The villages of Cowley, Coberley and Stockwell have not been properly consulted at any stage of the A417 missing link consultation and as such, another public consultation should take place to properly assess the impact that option 30 will have on the countryside and the surrounding villages.

I believe that a review of options today would not pick option 30 due to the environmental destruction that its creation entails. Option 12 and the tunnel option would achieve the aim of filling the missing link without so much environmental destruction.

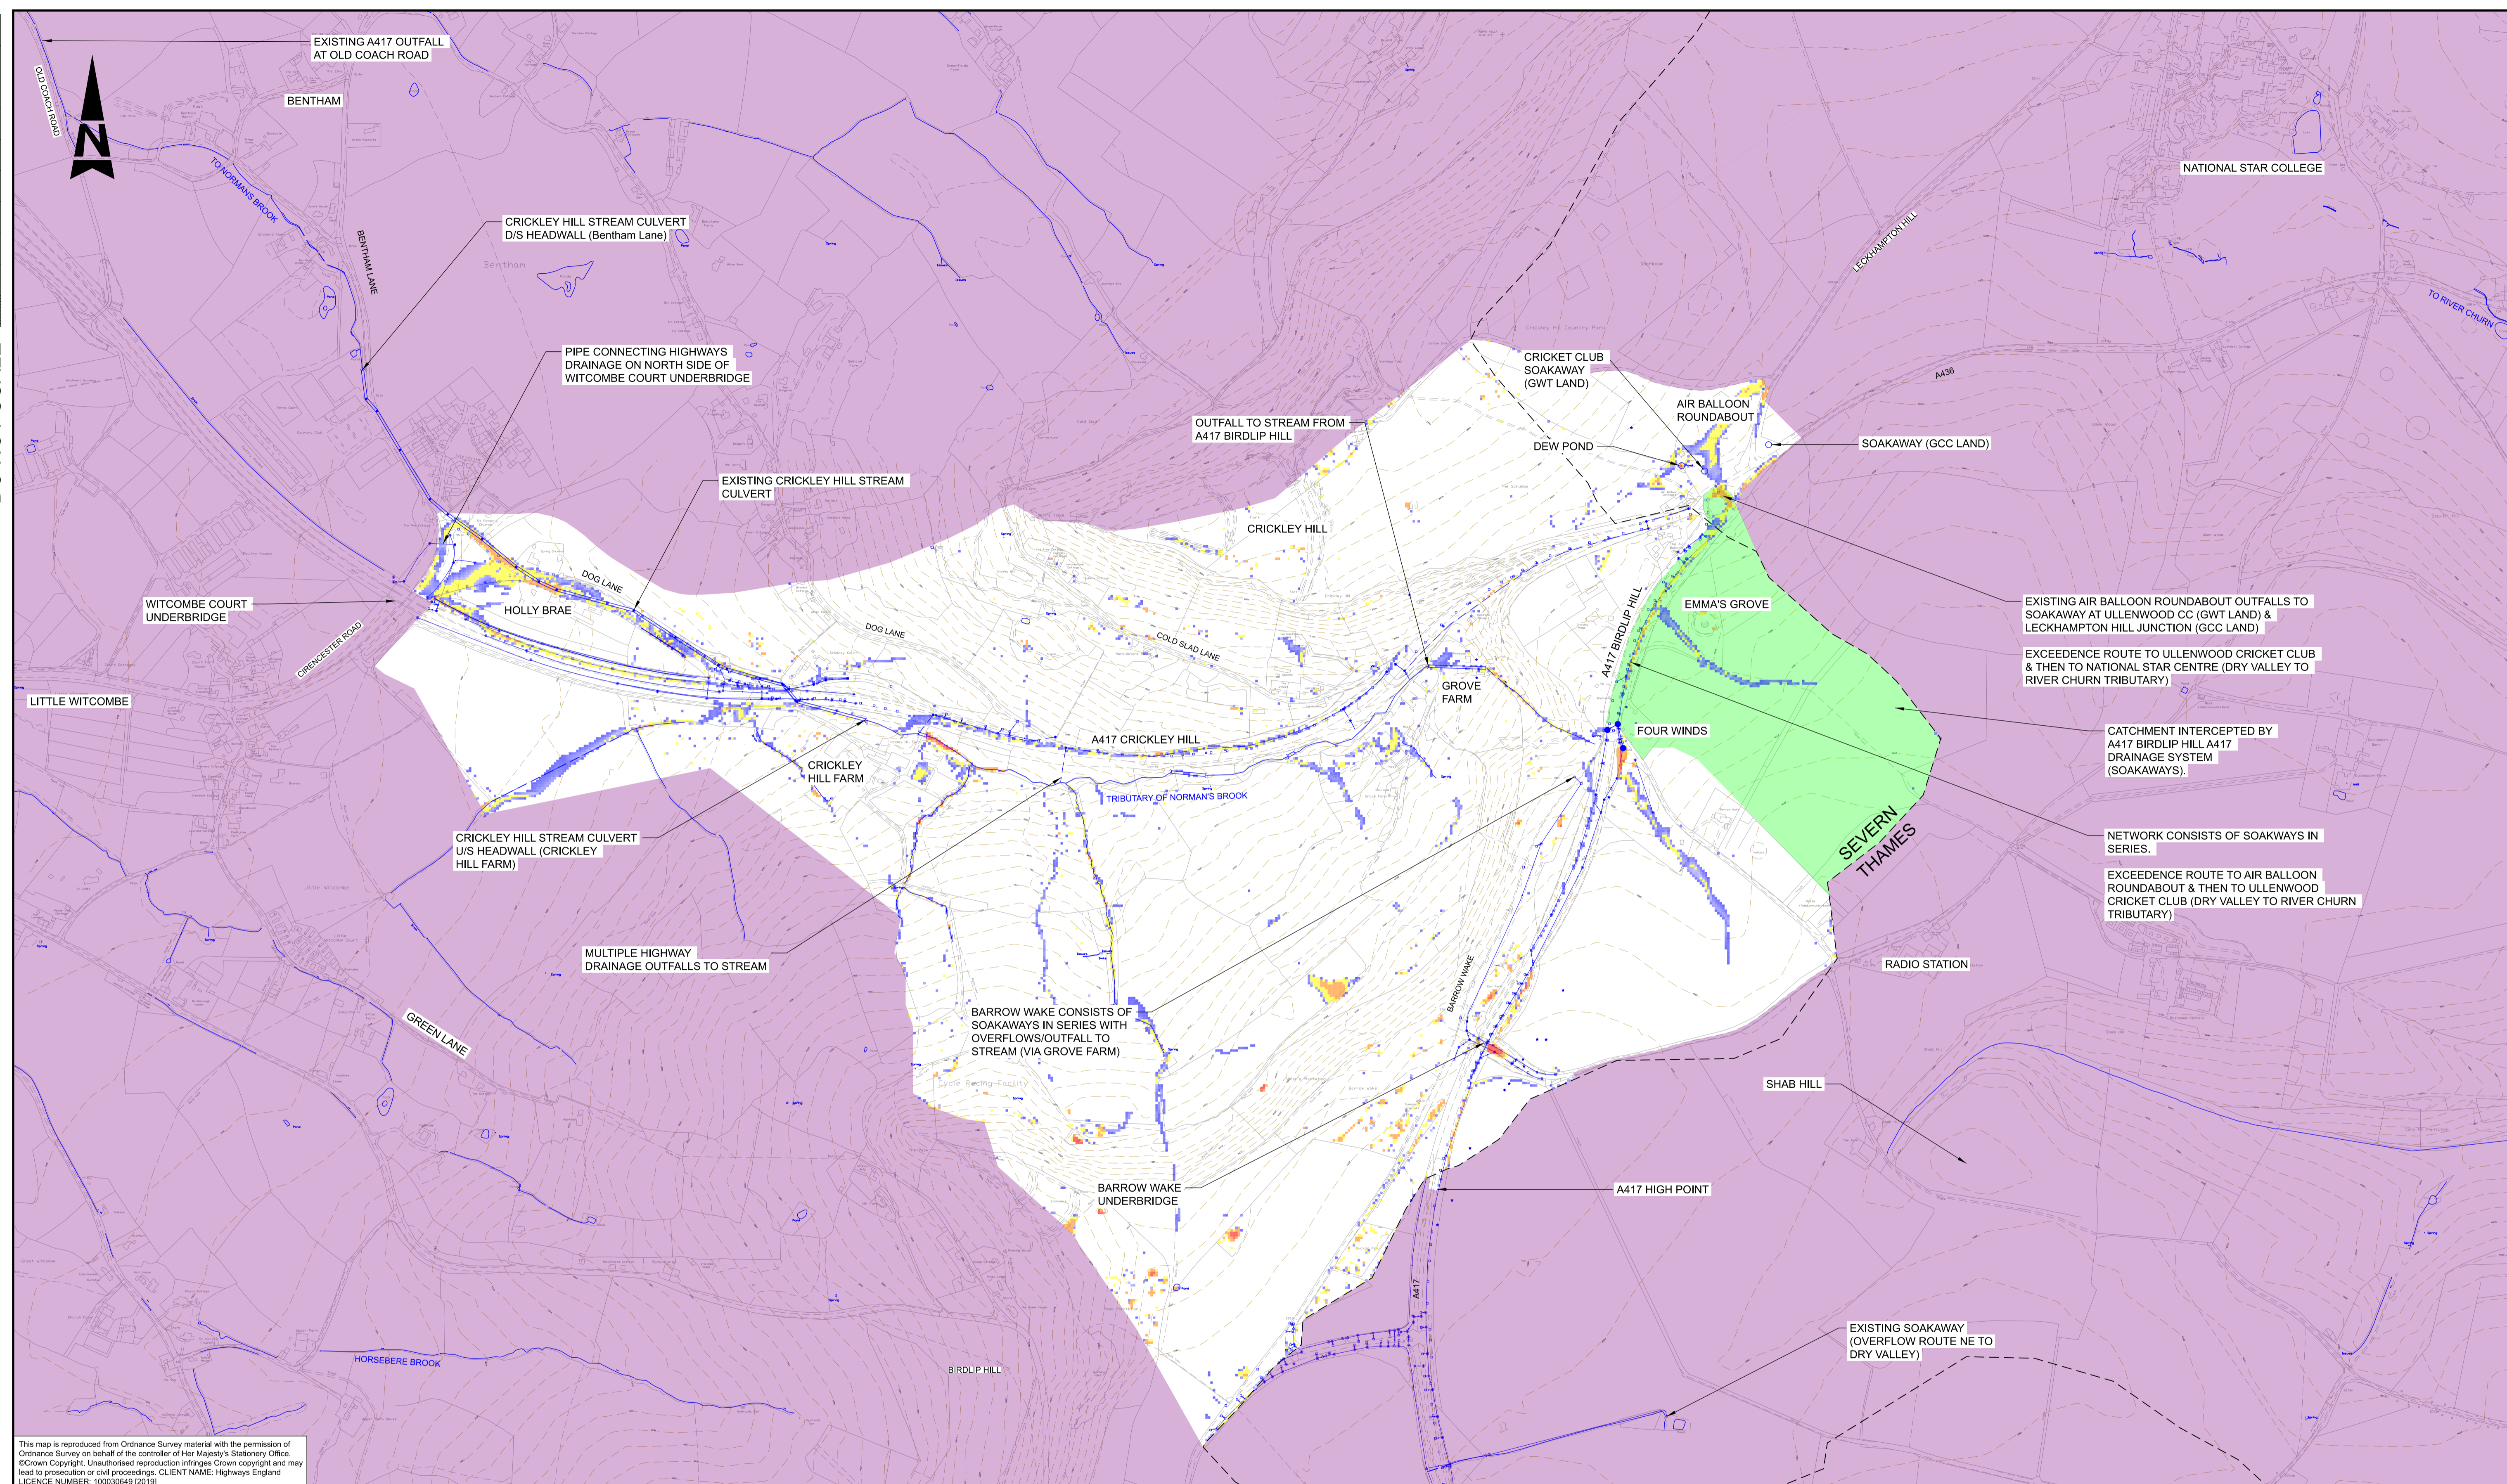
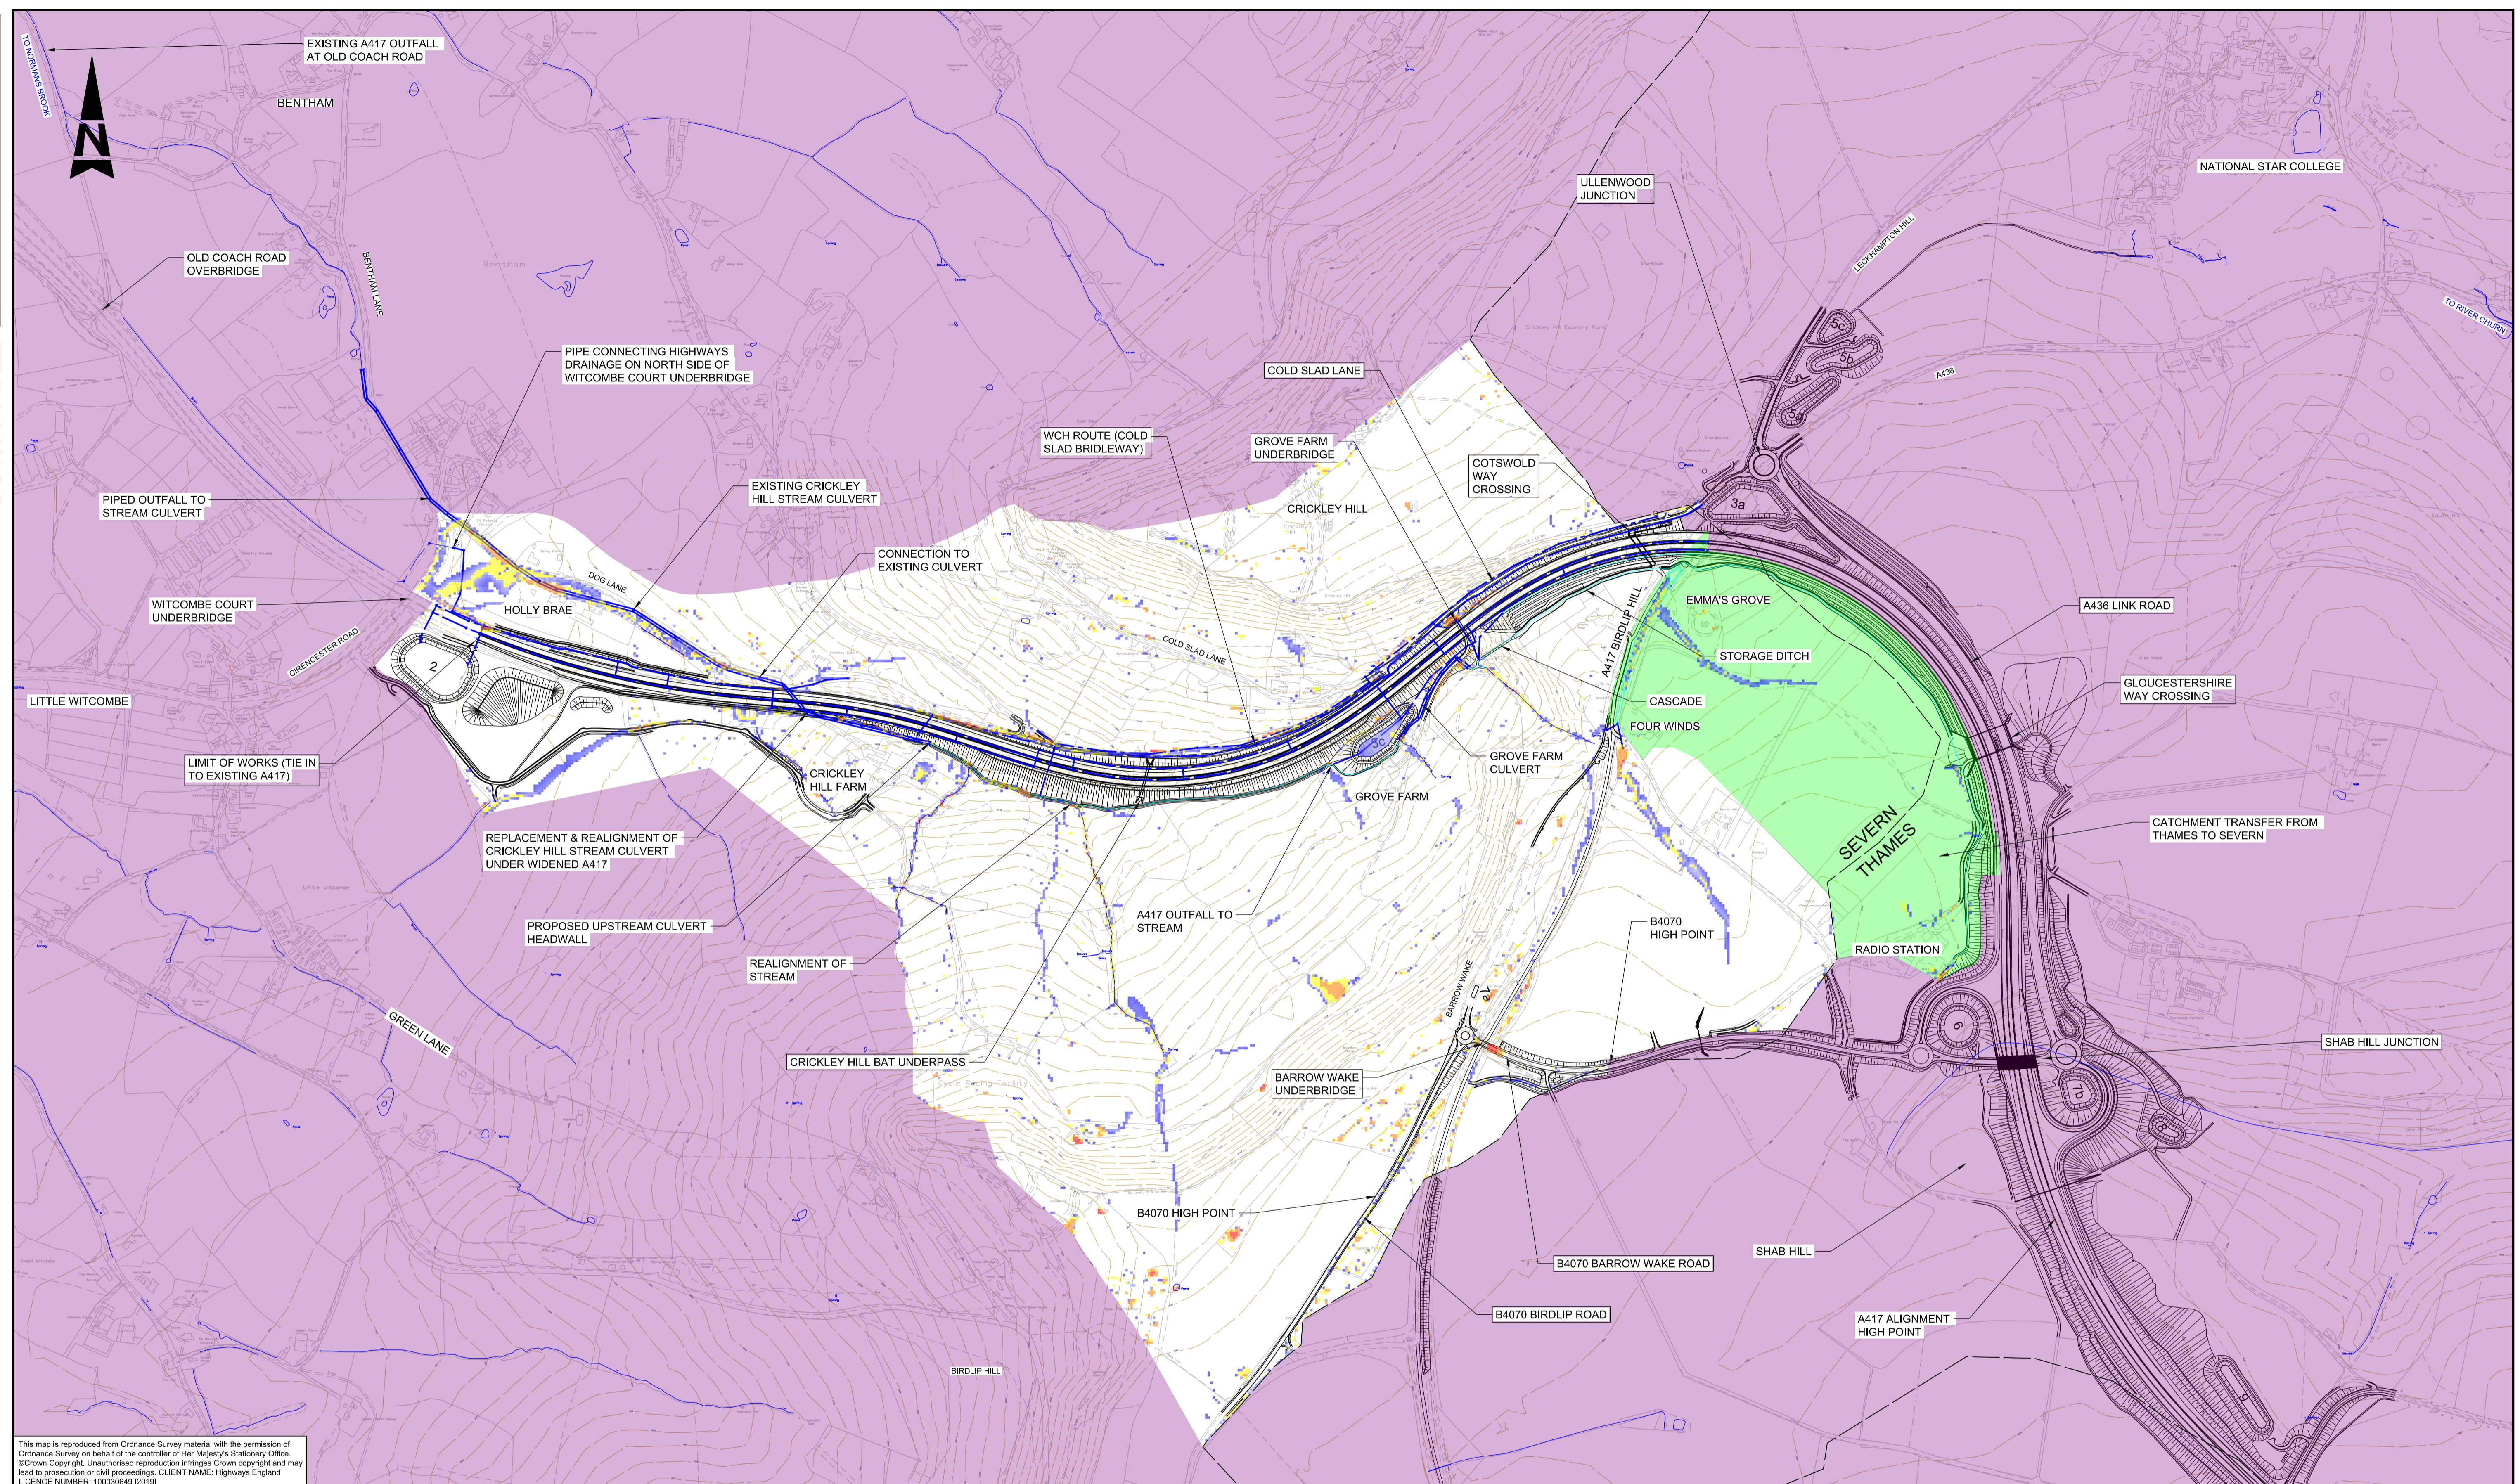
5. Has the frequent flash flooding of Cowley been taken into consideration? Option 30 can only make this worse, even with the proposed mitigation.
6. Has the effect of option 30 on the travel times of locals been properly assessed? The journey times for Cowley residents to travel West or South to Birdlip, Stroud, Painswick or Gloucester will be much longer if option 30 is put in place. The narrow road from the Cowley roundabout to Cowley is not a viable route and is considered unsafe by locals.
